# Appendix H - Existing Informal Passing Places and Proposed Improvement Locations

Reference plan showing existing & improved passing place locations

Drawing Number
 24071-LE-00-ZZ-DR-D-0110

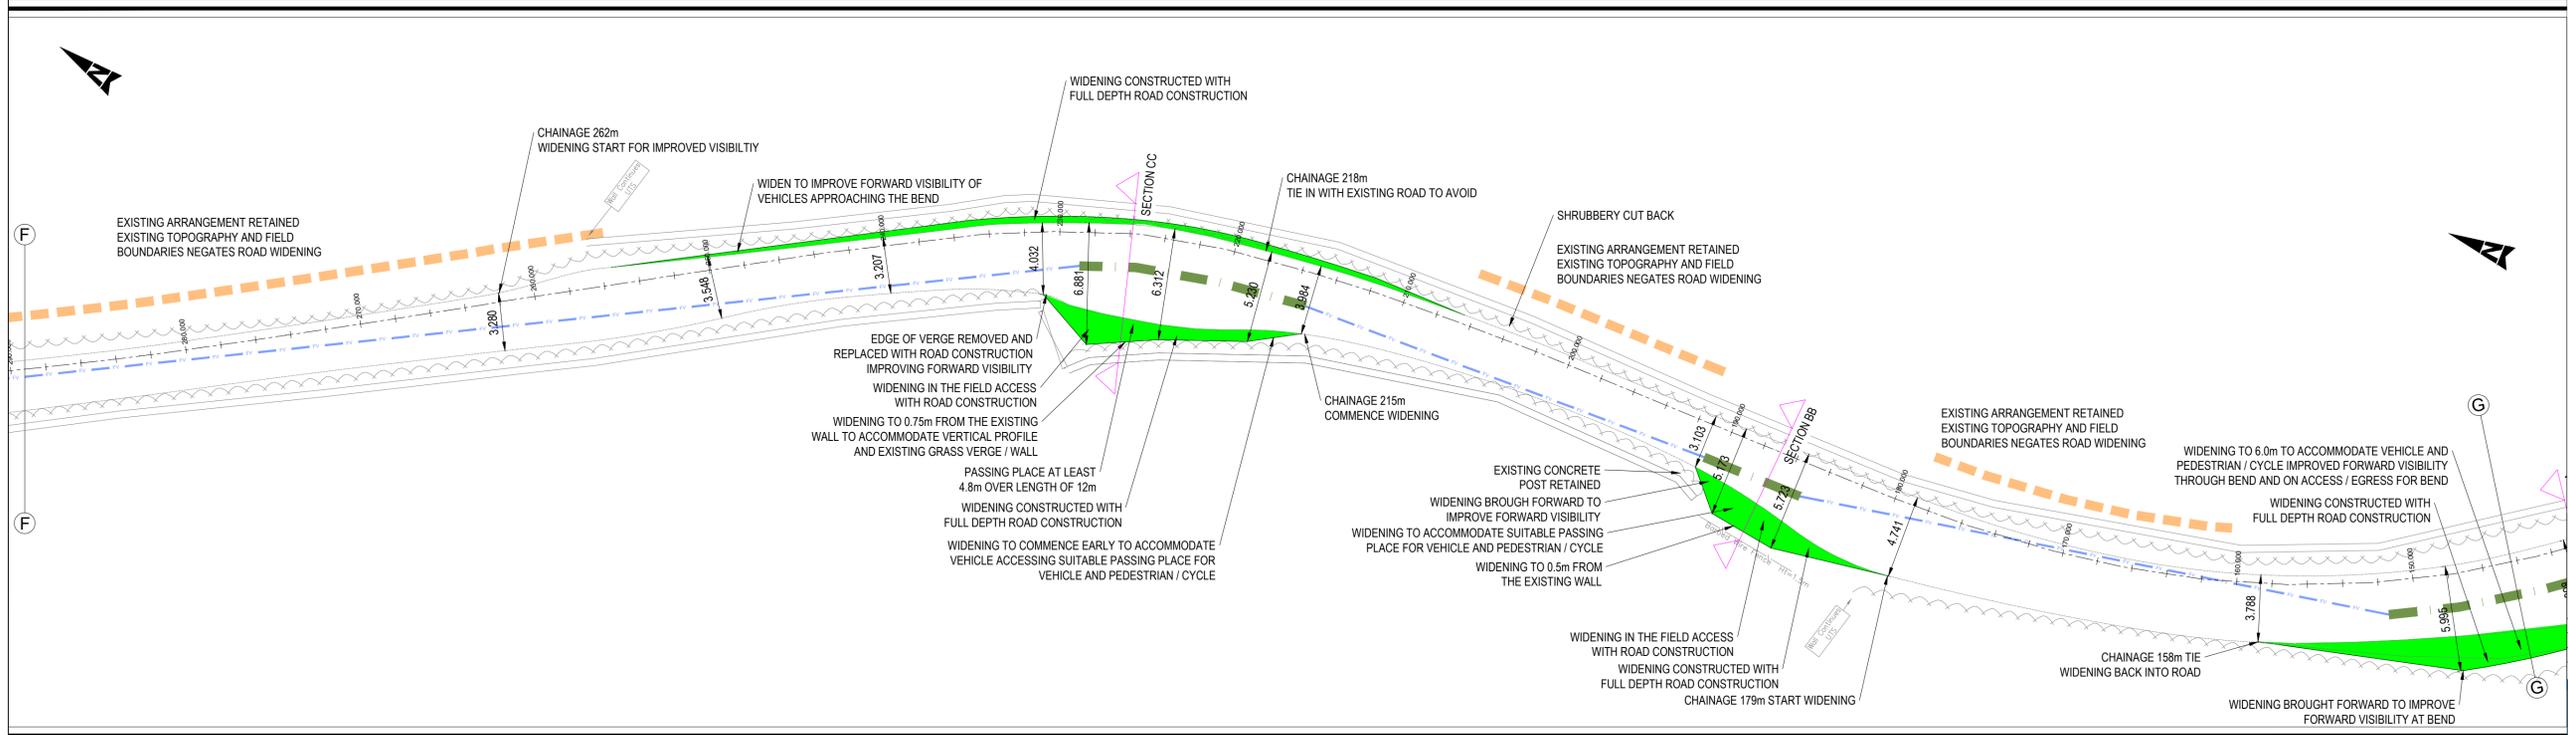
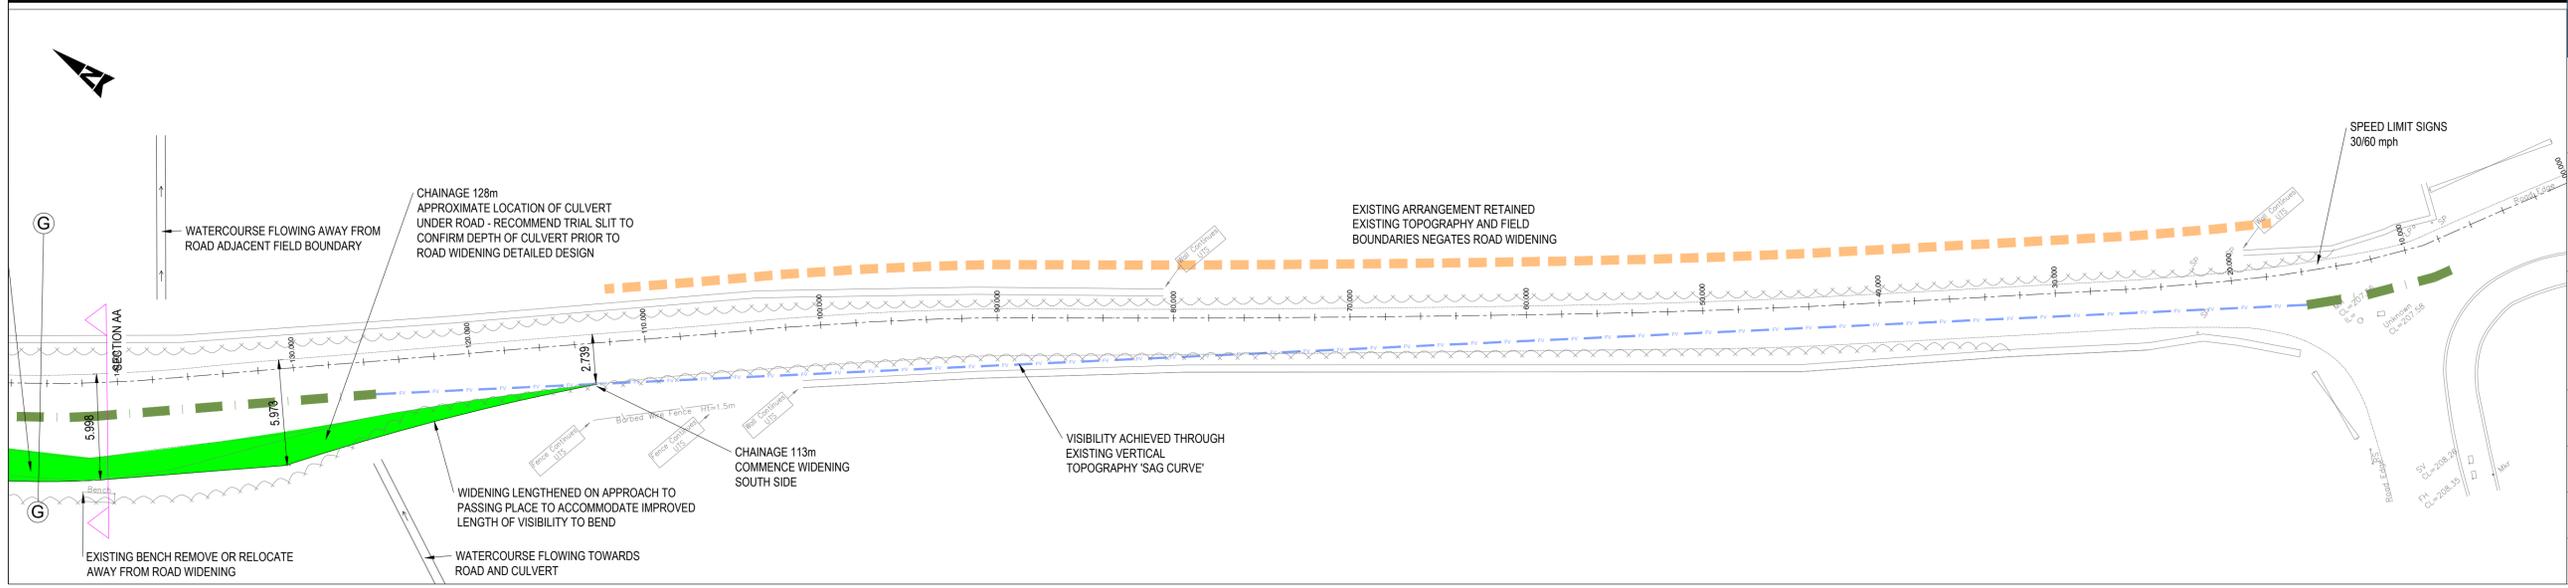
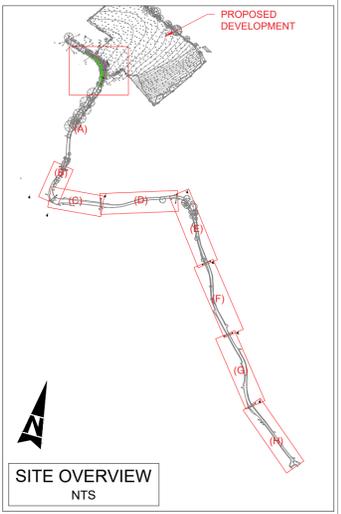
- There is already a passing place in this location, which is circa 10m long by 5.5m+ wide and can accommodate multiple cars. Therefore, the proposal effectively resurfaces the carriageway that already exists (or existed as it is currently eroded to sub-base level within the existing widening). As such, these works have only margin benefit by improving the existing carriageway surface.
- The improved carriageway surface may assist motor vehicle traffic, and potentially cyclists when passing. However, it may also increase traffic speeds, to the detriment of active travel users.
- The improvement to visibility noted on the plans is marginal (and has not been quantified).
- The suggestion to remove the bench is unacceptable.

- There is already a passing place in this location. Whilst the proposal increases the width of the passing place slightly, this additional width may have limited benefit. This is due to there being sub-standard forward visibility from this passing place (looking northwest), so drivers are unlikely to utilise the extra width, as this will result in their visibility being further restricted.
- The new passing place design includes an abrupt exit taper (1:1). Therefore, it is unclear whether a vehicle could effectively exit the passing place, and utilise the extra space provided.
- No swept path analysis has been provided, to confirm whether the passing place is functional.
- The passing place does include some additional width, which could increase capacity (if the spaces is usable, which has not been demonstrated) for circa two cars to pass, so may have some minor benefit.

- There is already a passing place in this location. Whilst the proposal increases the width of the passing place slightly, this additional width is minimal and would have limited benefit. There is also sub-standard forward visibility from this passing place (looking southeast), so drivers are unlikely to utilise the extra width, as pulling further to the left will result in their visibility being further restricted.
- No swept path analysis has been provided, to confirm whether the passing place is functional. However, the exit taper at this passing place is better than some of the other proposed designs, so may function adequately (but this has not been demonstrated).
- The passing place includes only minimal (if any) additional width, and the carriageway is already a reasonable width in this location (e.g. 4.8m+). Therefore, any benefit from these works is minimal.

- There is already an informal passing place adjacent to the field gate in this location. Whilst the proposal increases the width of the passing place slightly, and provides a hard paved surface that would be of benefit to motor vehicles and cyclists, no additional highway width is created. Therefore, there will be no material improvement in capacity of the existing informal passing place.

- The new passing place design includes an abrupt exit taper (1:1). Therefore, it is unclear whether a vehicle could effectively exit the passing place, and utilise the extra space provided. This is unlikely, given the narrow carriageway (2.9m) immediately northwest of the passing place.

- No swept path analysis has been provided, to confirm whether the passing place is functional.
- The extended passing place is unlikely to be deliverable as shown, as the exit taper impacts on a boundary wall (that has been damaged by existing vehicle overrun, but not shown on the plans) adjacent to the field entrance. It is noted that boundary walls do not typically form part of the highway, so it is unlikely that the wall could be removed and the additional land dedicated as highway to provide the extended passing place (even if it were demonstrated to be functional, which does not appear to be the case).

- There is severely restricted forward visibility looking northwest from this passing place, which is not improved in any way by these proposals. The visibility is restricted due to vegetation on the inside of the right hand bend to the northeast, which cannot be significantly improved, as there are trees that block visibility that are generally beyond or straddle the highway boundary. This includes a large oak tree (not shown on the Appellants drawings, as is the case for many trees that are missing from the drawings), which would need to be removed to increase visibility to acceptable levels. However, the removal of the oak tree is unlikely to be acceptable (and has not been identified or assessed).

- Small vehicles already pass in this informal passing place, by overrunning the adjacent highway verges. However, the width of the highway in this area is inadequate to allow two cars to safely pass (e.g.  $4.8\text{m} + 2 \times 0.5\text{m}$  offsets from walls =  $5.8\text{m}$  total highway width required). Therefore, the  $4.2\text{m}$  wide formalised passing place that is proposed would be ineffective, and provide little if any improvement over the current situation, with this passing place being well below standard.

- The proposed carriageway widening is also staggered due to existing trees growing within the adjacent verges and walls (that are not shown on the plans). This results in the effective length of the passing place being circa  $3\text{m}$ , which could not accommodate a vehicle.

- No swept path analysis has been provided, to confirm whether the passing place is functional, although it is quite clear that this would demonstrate that it is not.

- The passing place is shown built up to boundary walls, which will not provide safe clearance for drivers. However, this is more of concern for cyclists, who require a minimum of  $0.5\text{m}$  clearance to avoid clashes with their pedals and handlebars. Therefore, this formalised passing place would not benefit cyclists.

- It is unclear how this widening would be undertaken. However, it appears that it would require upgrade of the boundary walls, which has not been identified on the plans. This is likely to require works that are beyond the highway boundary, so it is unclear whether the proposal is deliverable.
